Planning Application Response

Local Authority:	Barnsley
Detail:	Up to 215 dwellings and new vehicular access onto Shaw Lane, Carlton
Planning Ref:	2022/0115
Link:	https://www.applications.barnsley.gov.uk/PlanningExplorerMV/C/Home/ApplicationDetails?planningApplicationNumber=2022%2F0115#documents
Deadline:	15 th March 2022
Submitted by	Trans Pennine Trail National Office

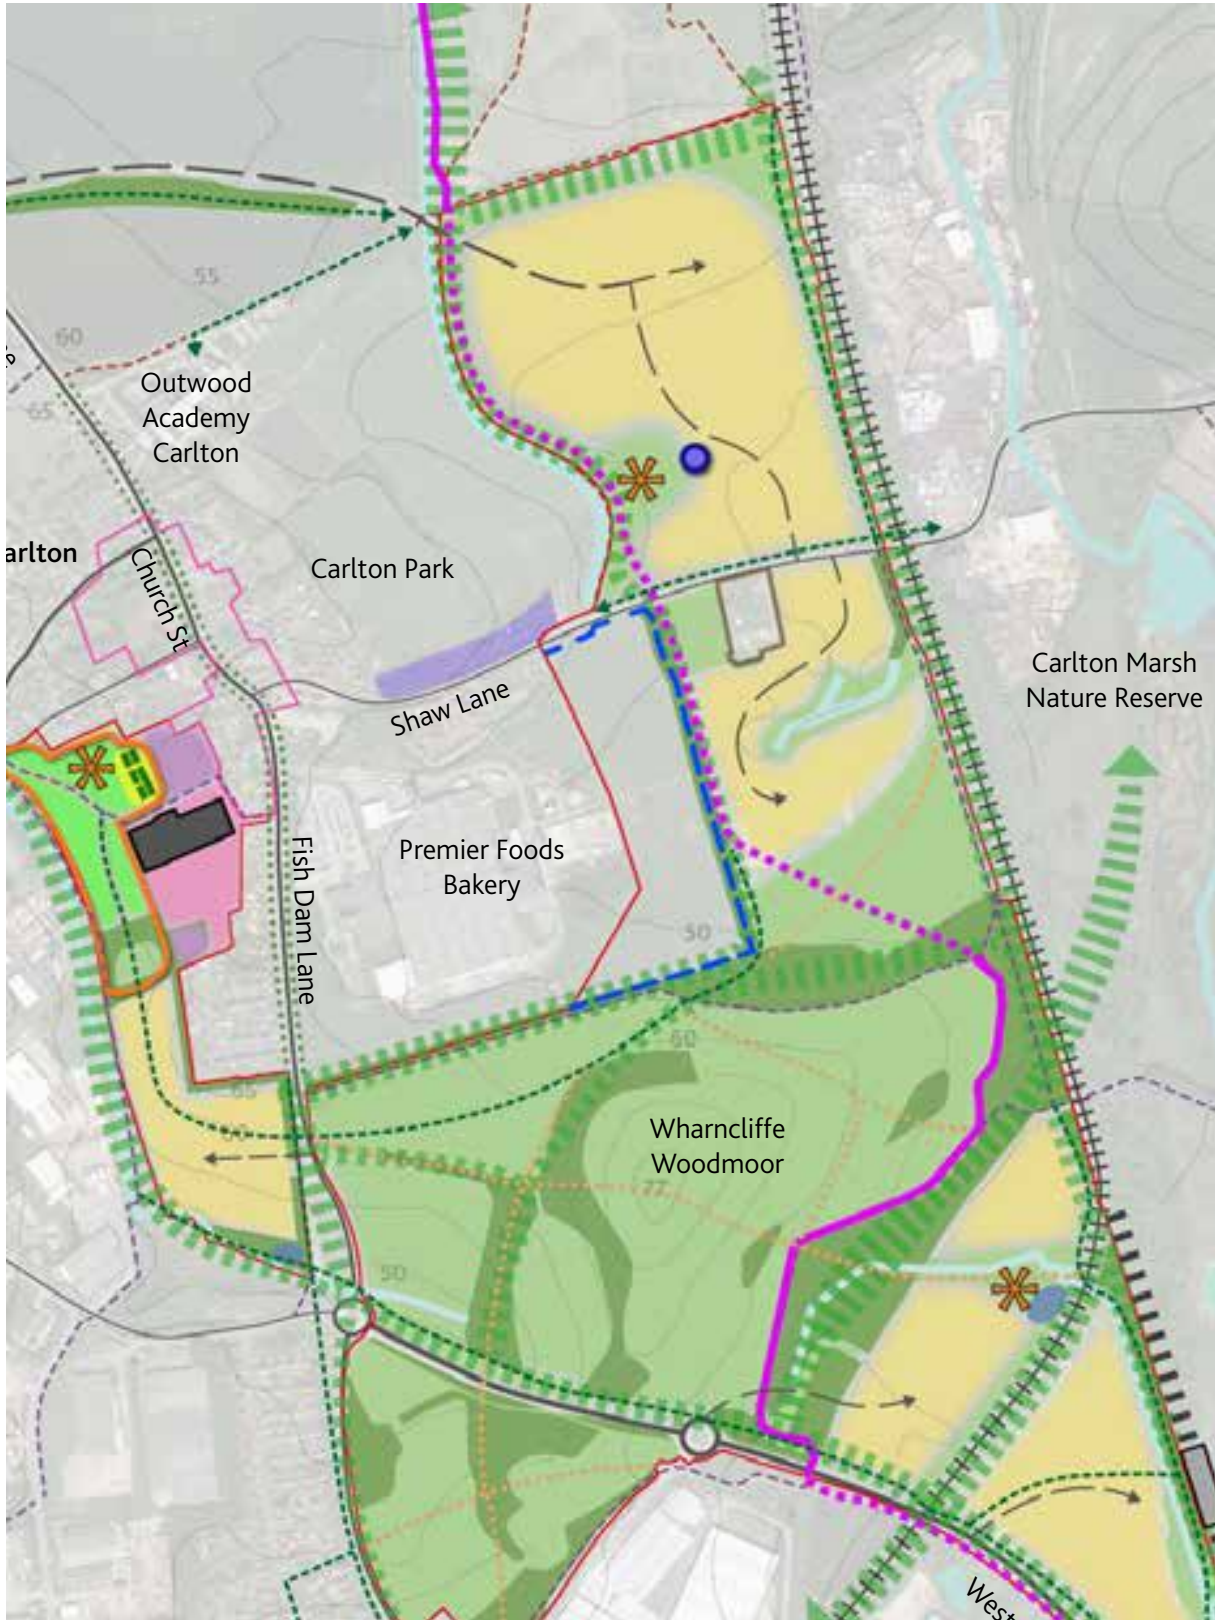
Pg 5	Introduction image – the alignment of the TPT is shown incorrectly. This was noted at the pre-app stage and has not been changed. The alignment should be shown as above.
Pg 9	Context – incorrect image (as above)
Pg 11	Plan should include the Trans Pennine Trail and not just the site and PROWs to highlight the importance of this national route.
Pg 14	Analysis – it is important that the Trans Pennine Trail is noted within this point as a key sustainable transport multi-user route directly adjacent to the site.
Pg 16	As above – walking routes are mentioned but not the multi-use route of the Trans Pennine Trail.
Pg 21	The alignment of the Trans Pennine Trail is incorrect.
Pg 24	Notes the consultation responses to the pre-application were positive. The TPT objected to the pre-application and this should be reflected within this statement.
Pg 26	Active Travel Routes: Footpath 30 is also the Trans Pennine Trail – full multi use. A connection from the site to the Trail is not mentioned but would be welcomed. (This is shown on the illustration on page 31) Footpath 31 is also the Trans Pennine Trail - full multi use. A connection to the Trans Pennine Trail is welcomed. Improvements to the TPT along Shaw Lane as indicated in the plan would be supported. All active travel routes and new routes should be designed to LTN 1/20 standards as a minimum. Note full multi-use is a route for walkers, cyclists and horse riders.

Active Travel

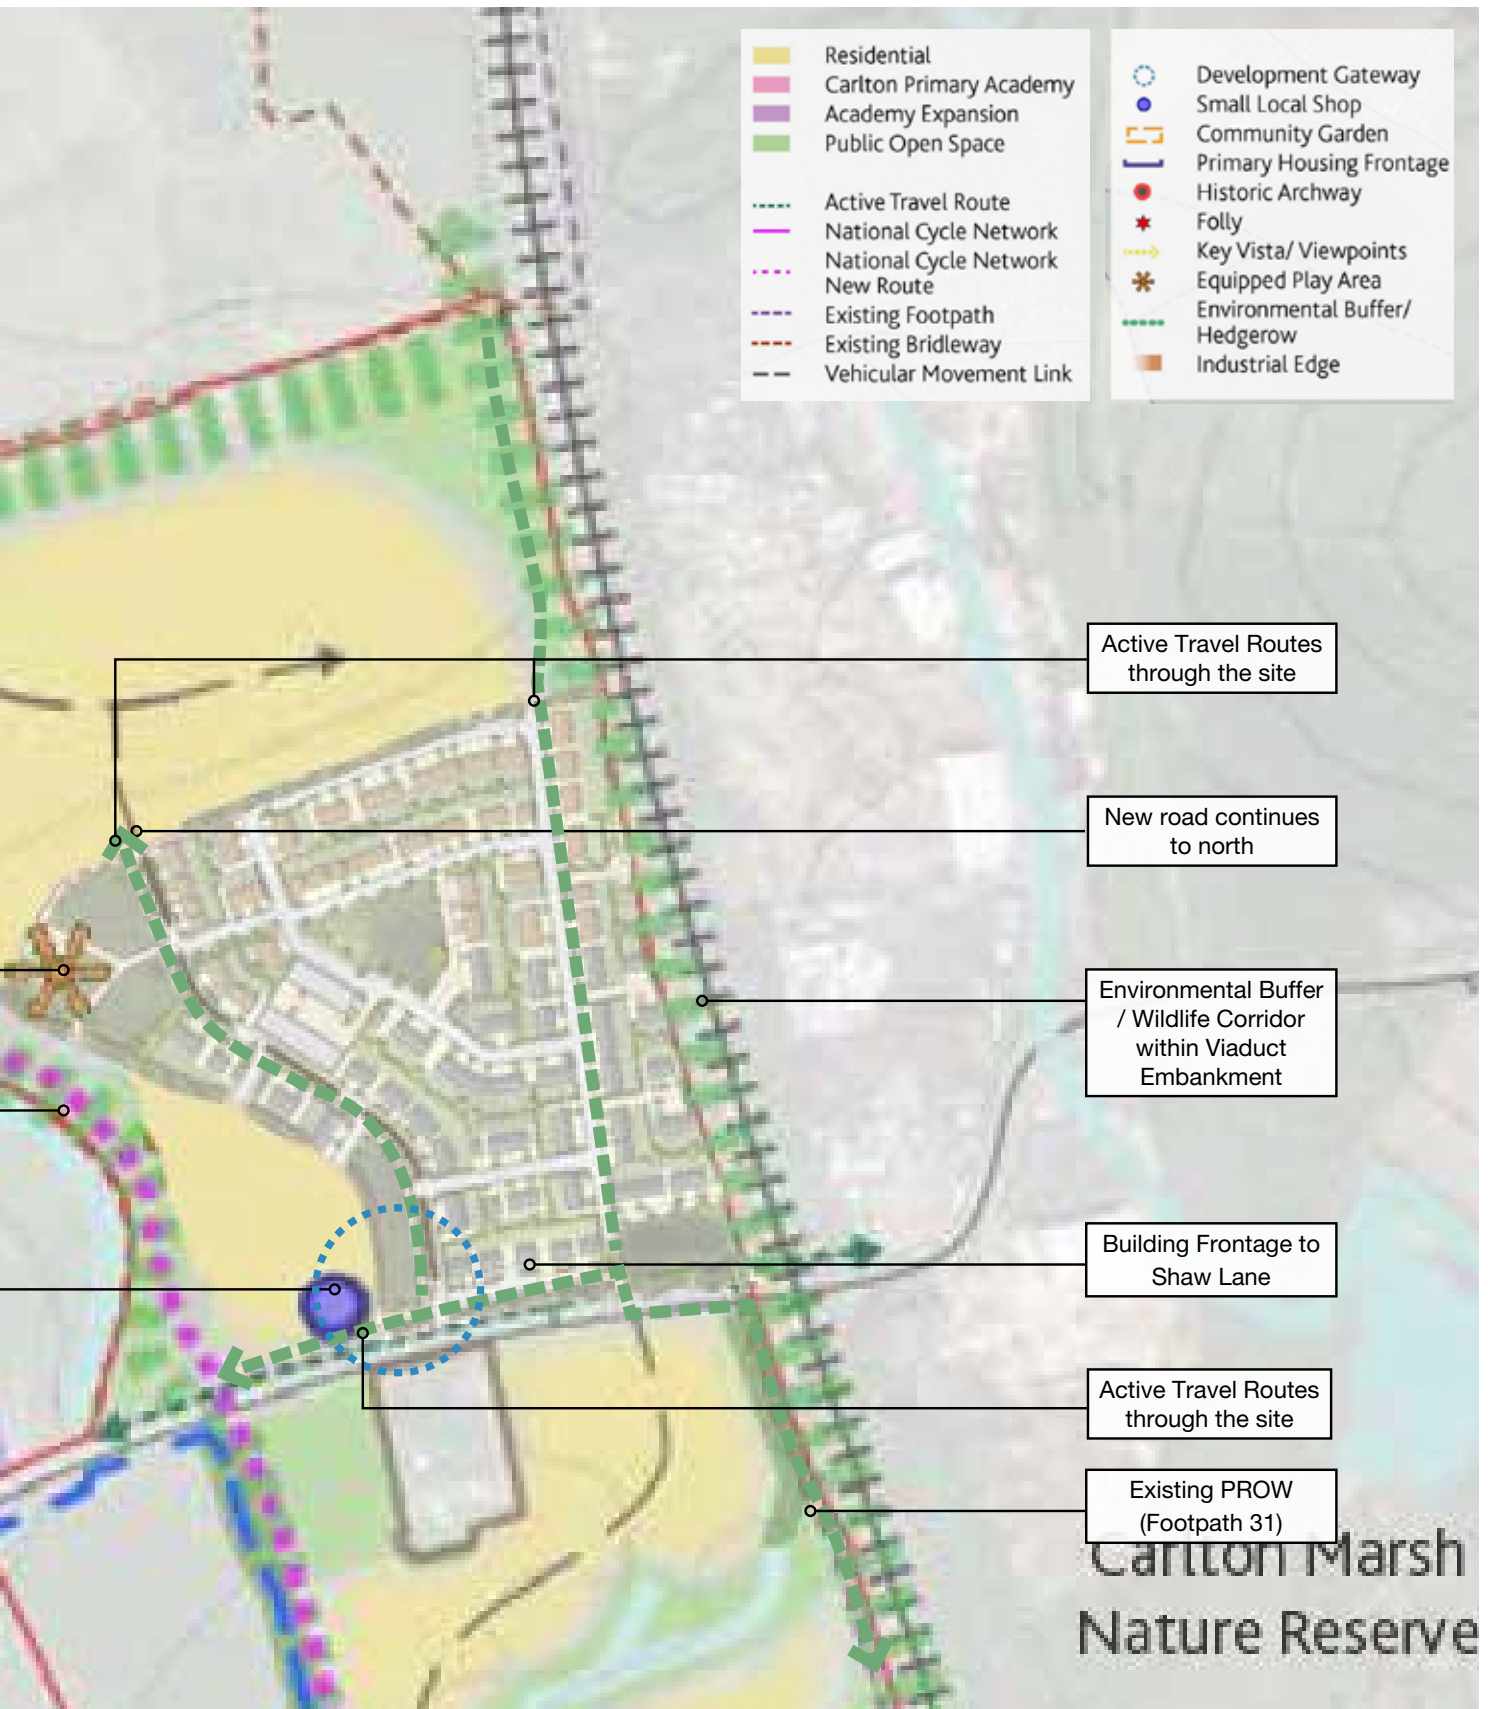
Pg 52	Improved connectivity: Should note that these are also connections to the Trans Pennine Trail network.
	Pg 54	Will the active travel routes through the site be designed to LTN1/20 standards?
	Pg 56/57	Details secondary routes and tertiary routes to provide for footpath only – are there no plans to incorporate a safe cycle route as part of the secondary routes through the site?
	Pg 63	Walking and cycling provision should be designed to LTN1/20. Cycle parking should also accommodate adapted cycles.
